RE: EIS Review – Cabramatta Rail Loop Project (SSI 9186)

A review of the following documentation has been undertaken:

- Environmental Impact Statement: *Cabramatta Loop Project – Environmental Impact Statement*, dated 15 August 2019, prepared by ARTC;
- Technical Report 8: *Historical Heritage Assessment and Statement of Heritage Impact*, dated 7 August 2019, prepared by Biosis;
- *Technical Report 10: Landscape and Visual Impact Assessment*, dated August 2019, prepared by GHD; and
- Technical Report 2: *Noise and Vibration Impact Assessment*, dated August 2019, prepared by GHD.

Plate 10 Indicative design of signalling location hut to be installed within the study area (note the signalling hut will not be fenced as it will be located within the fenced rail corridor)

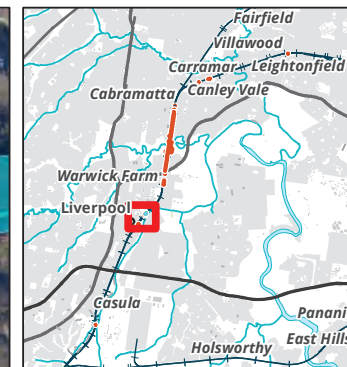
The proposed signalling hut will measure 5m(L) x 3m(W) x 2m(H). It is recommended that the proposed signalling hut material and colour be selected to blend in with the general colour and material pallet of the rail corridor.
